Appeal Decision

Appeal Ref: APP/R5510/Z/22/3310367

Pavement Outside 80 Ruislip High Street, Ruislip HA4 7AA

CONVERSION – SITE PHOTO

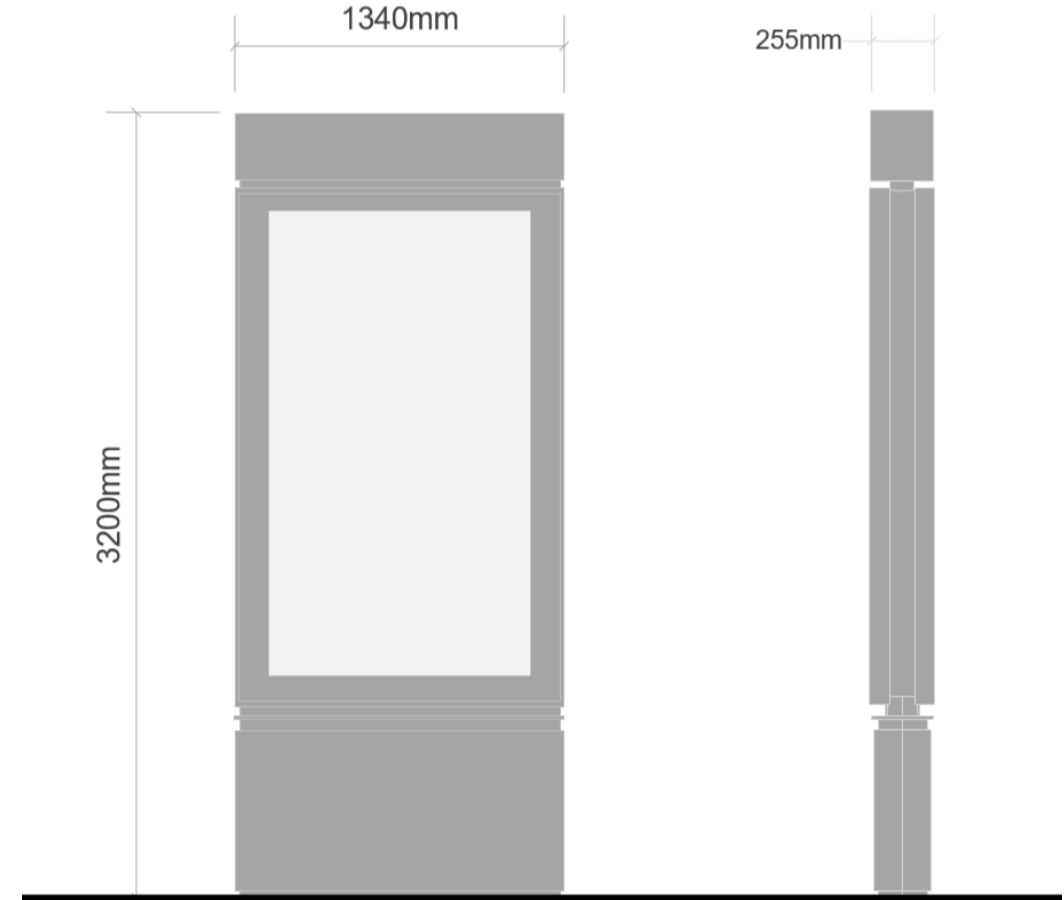
6. The appeal site is in a prominent gateway location, close to the western junction with Midcroft (B466) in the northern part of High Street. The proposal would be located outside No 80, which is part of a classically inspired building identified in the Appraisal as a 'key unlisted building' that contributes positively to the significance of the CA, despite some modern shopfronts at ground level. The location is also a termination of a 'key view' identified in the Appraisal. The existing double-sided poster display unit is a negative feature at the appeal site.

7. As the proposal is a replacement for the existing poster display unit, it would not create additional physical clutter or obstruction within the pavement. Nevertheless, it would have a more solid form compared to the existing unit, and due to its design, colour, and double-sided digital display screens, would be overtly more modern and eye-catching in appearance. It is also significant that the images on the digital display screens would change at regular intervals, whereas the current poster displays do not.

8. Consequently, the proposed digital advertisement unit would have a greater degree of prominence in the street scene. In my judgement, it would be a jarring feature against the key unlisted building it would be closely experienced with, and unduly intrusive in this important gateway location and 'key view', both individually, and cumulatively with other advertisement units in the vicinity, including another nearby freestanding unit outside No 63. This would be the case even if the levels of illumination and the speed and frequency of image transitions on the display screens were carefully controlled.
